Our Ref: LU/396/21/DOC

Approval of details reserved by condition imposed under LU/135/21/L relating to conditions 3-full details of new external doors & windows, including sections & treatment along with details of new porches; 4-details of proposed removal of existing traditional windows; 5-details of all new internal joinery such as doors & skirting boards; 6- details of the proposed location, heights, materials & finishes of boundary treatments.

The Farm 39 East Street Littlehampton BN17 6AU

Arun District Council have decided to **REFUSE details reserved by condition for the following reasons:**

Drawing Name
Elevations - Proposed Discharge of Conditions

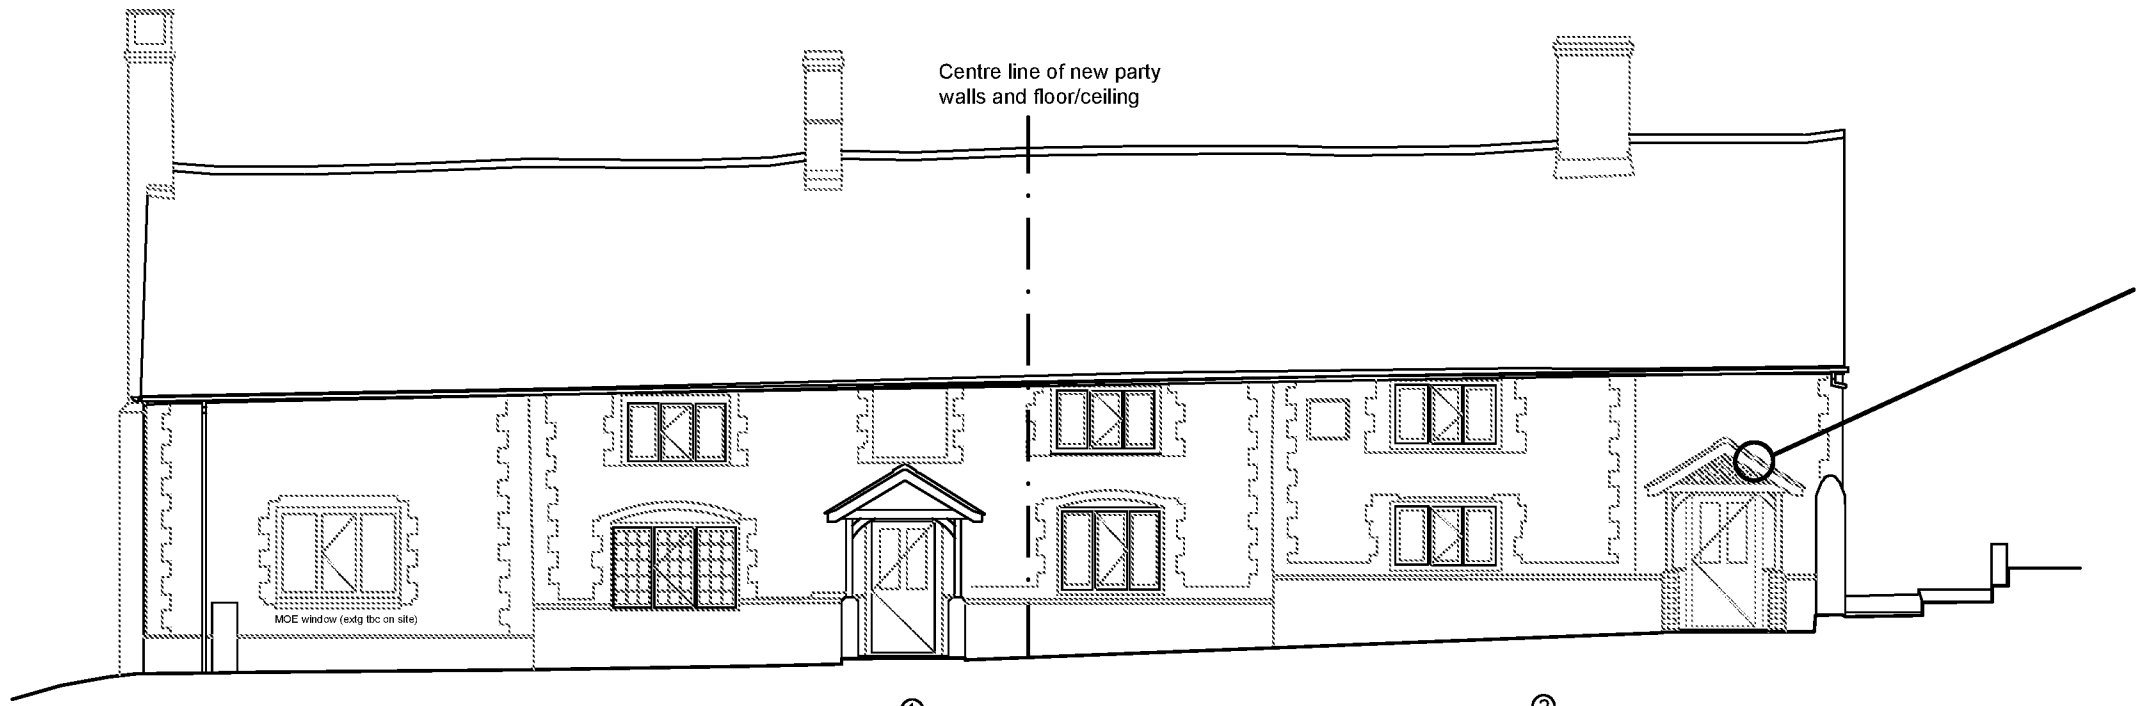
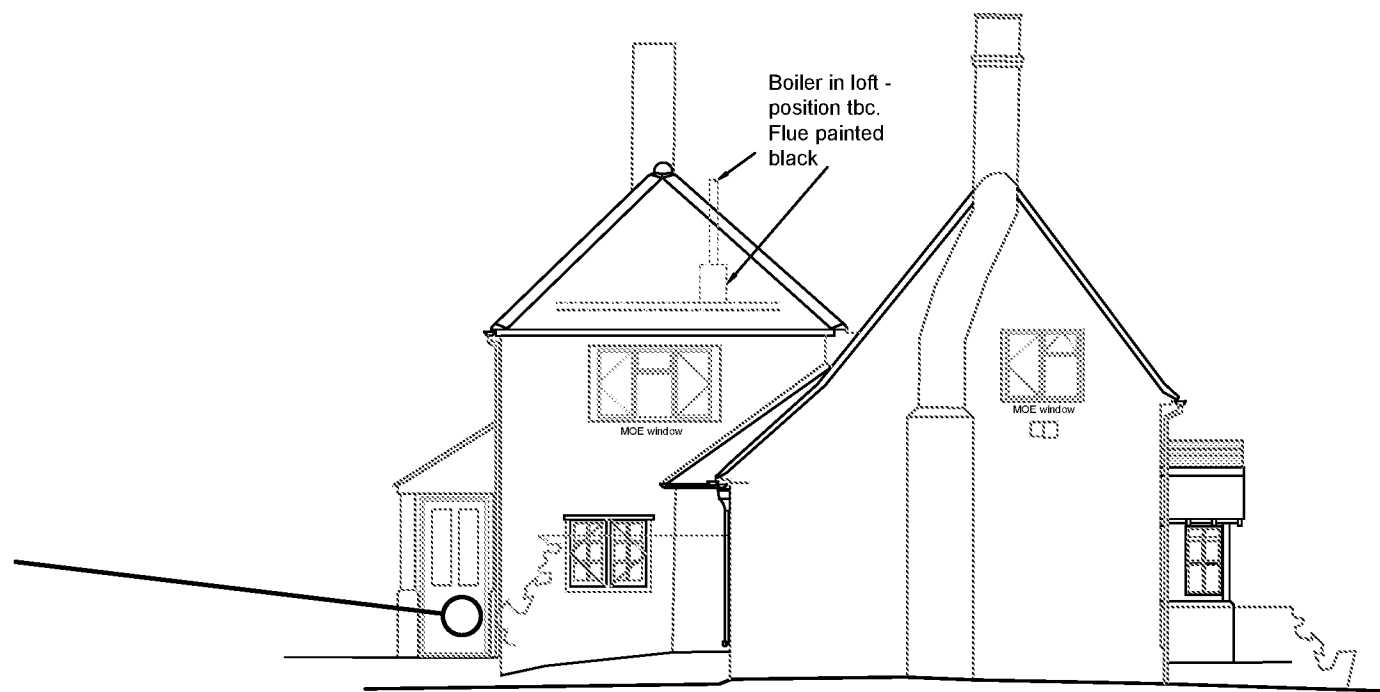
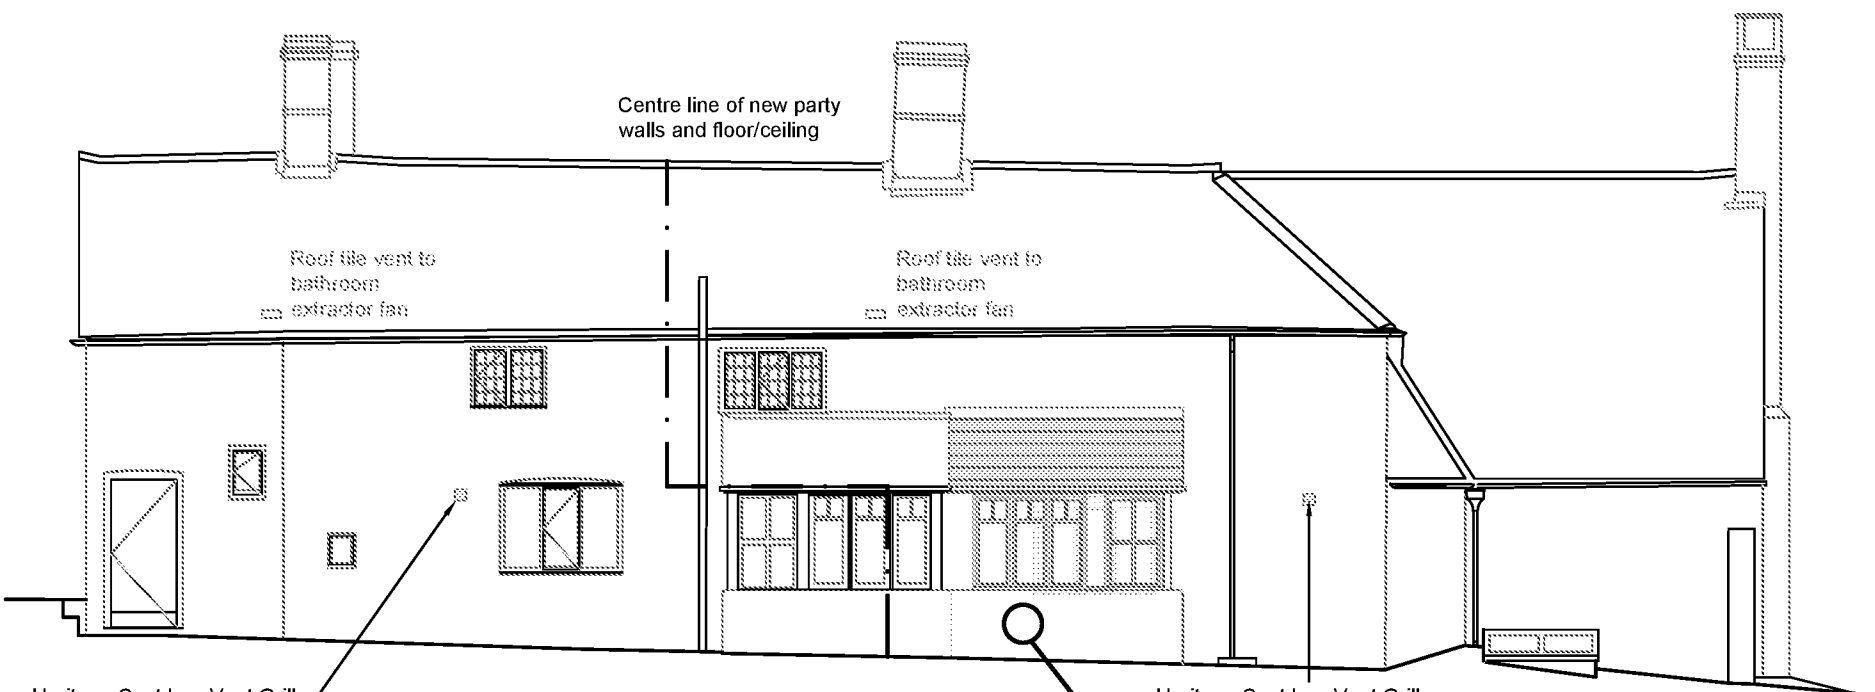
Insufficient information has been provided to discharge condition 3 with regards to details of new doors and windows including details of new porches required by condition 3 of LU/135/21/L. The applicant provided further information and details which have been reviewed by ADC Principal Conservation Officer, however, they were considered to be not sufficient for discharge of the above condition.

For the above reason and in the absence of required details the condition 3 cannot be discharged and you will need to make a revised submission.
